Application No: BE/149/20/PL
Site Address: 339 Chichester Road Bersted PO21 5AN
Description of works: Replacement of blockwork boundary wall with fence & new vehicular access. This site is in CIL Zone 4 (Zero Rated) as other development.

Thank you for your internet representation made on 12th January 2021 which has been recorded as an objection with the comments as follows:

SITE PLAN

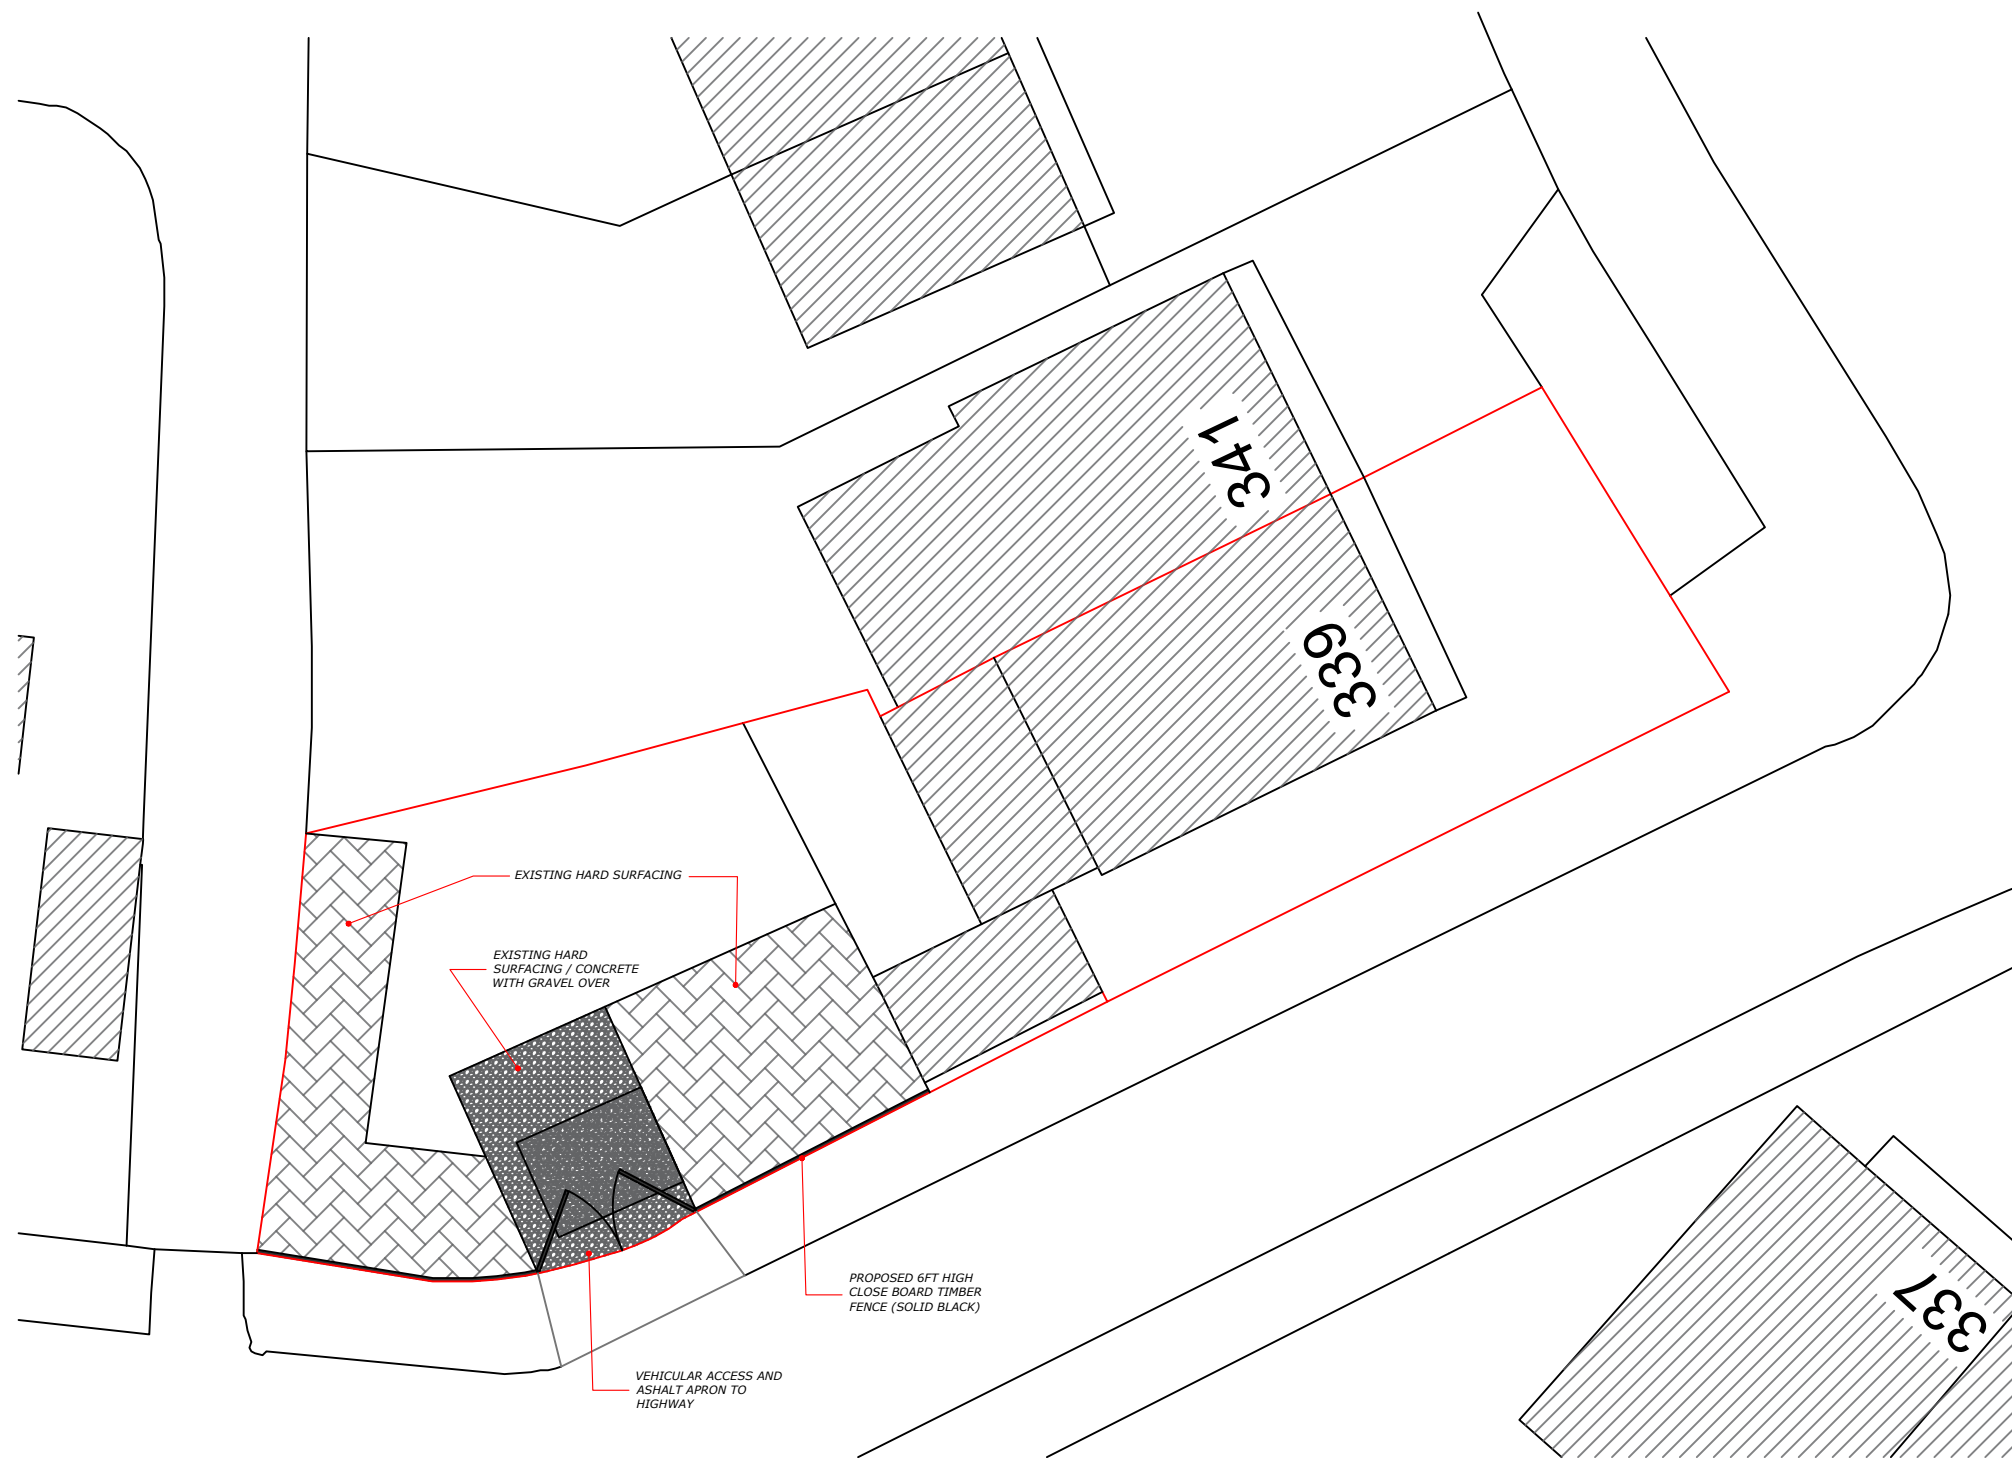
Regarding the proposal "Replacement of blockwork boundary wall with fence & new vehicular access". Firstly, when addressing the matter of the location of the proposed access. This is a significant hazard due to vehicles accessing the road from the Chichester Road end, and pedestrians using the footpath in either direction.

339 Chichester Rd has off road parking for a minimum of 3 vehicles which is reasonable for a 'B&B/hotel' with 3 bedrooms, and this application is for 1 more space; which seems to be a very large area and significant expense for one vehicle. This leads to the assumption that this 'off-road parking' is planned for use as a depot for Mr Delaney's company vehicles, particularly as they have been parking along that part of the footpath for some time anyway. This road is a residential road, not for commercial/industrial use, and I would strongly challenge it being used for these purposes. I would also like to highlight the potential future housing developments in the North Bersted area, which is likely to increase traffic through Bedford Ave. Approving this application will not only add to the expected volume of traffic, but increase the risks to pedestrians, vehicle collisions, and accelerated road surface degradation.

A dropped kerb (and bollards removed) has already been installed at this location and as the building is a business and a converted house, I'm assuming that planning permission has been sought and approved for this? Also, this completed work is concerning as it gives the appearance to residents that planning permission for everything else is likely to be approved (possibly even the office in the 2019 application), even though it's still in the consultation phase. If this isn't the case, then perhaps the bollards preventing vehicles from parking have been removed in their anticipation of a successful judgment. Because of this there is now a risk of Delaney vans (or other vehicles) parking on the dangerous corner even if the application was rejected.
